ICC Hotel, Response to NSW Department of Planning & Environment queries

Please find below our responses to each of the queries as raised by NSW Department of Planning & Environment.

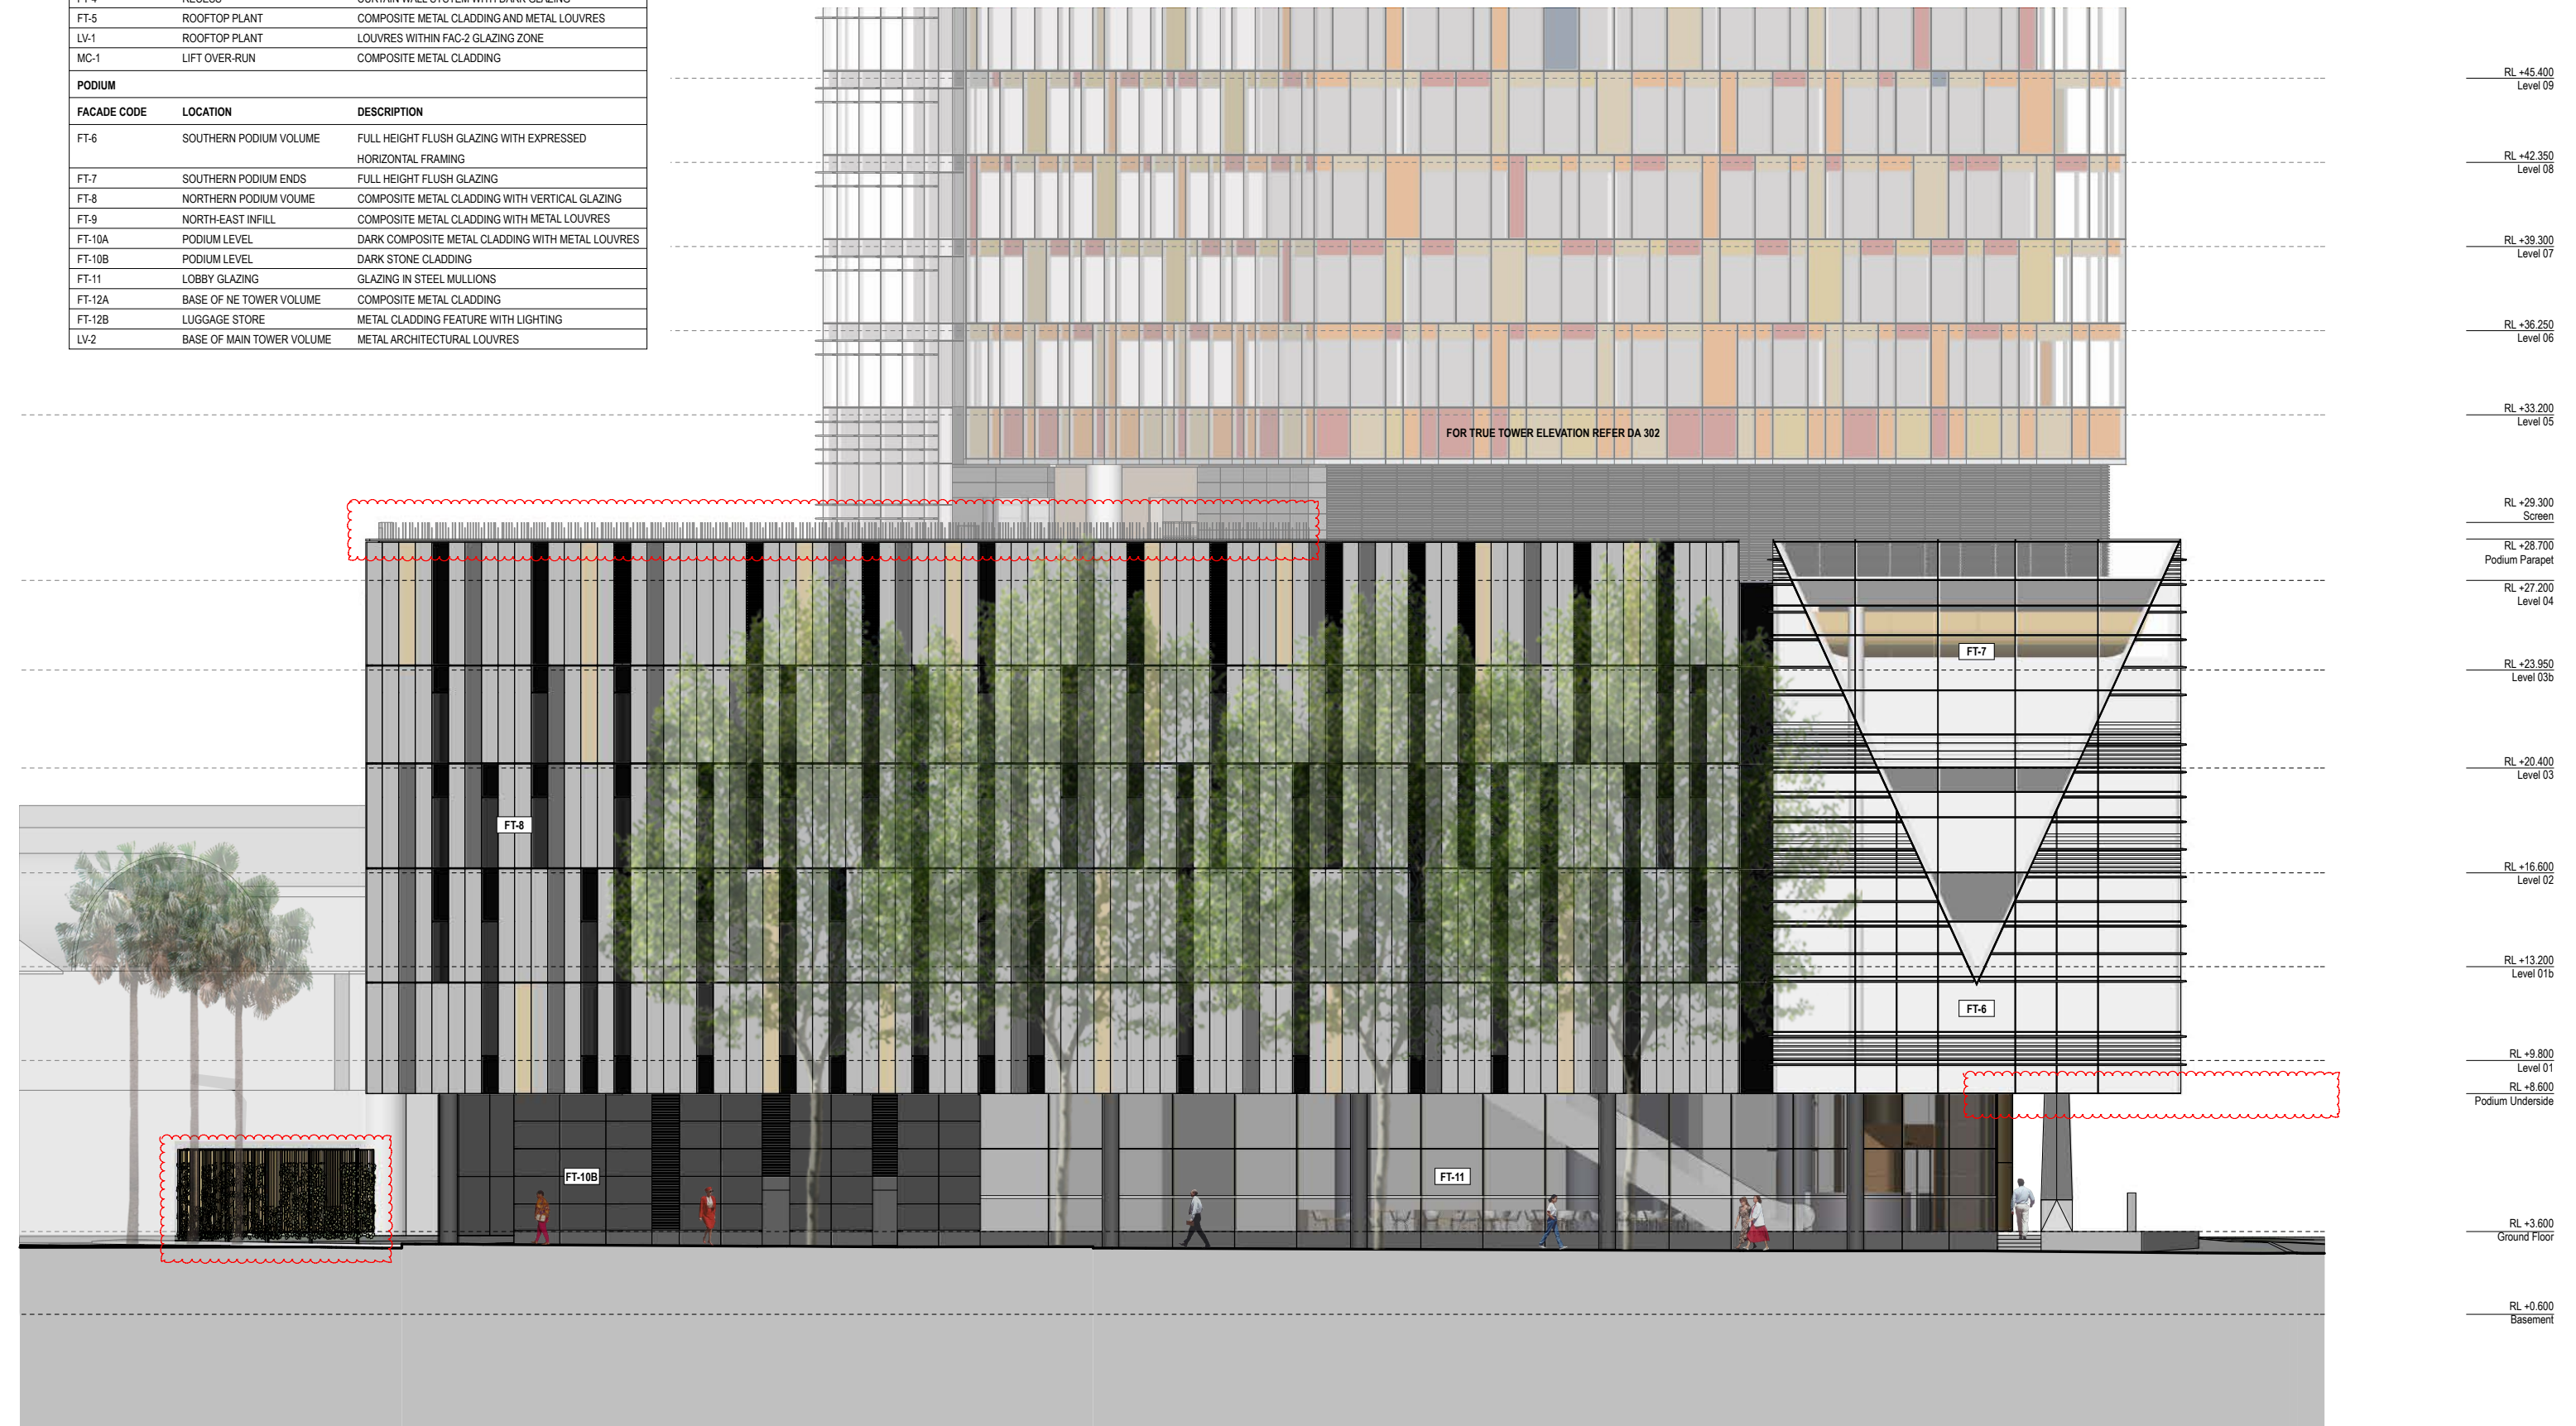
- c) The colour panels on the side and rear elevation of the tower have been reorganised and the intensity of the colour has been strengthened at the higher levels of the tower;

The colour strategy remains as per the above. The coloured panels are set behind an outer layer of glazing. As such, final colour selections need to be made with

consideration of the reflectivity and tone of the outer glass. The final distribution of colour is being developed to best achieve the design intent as noted in the March 2014 Supplementary Design Report. These refinements have occurred as part of design development and if not for this s96 application in our view would be certified by the PCA as being 'generally in accordance with the DA design'. The intensity is not proposed to significantly change or be strengthened.
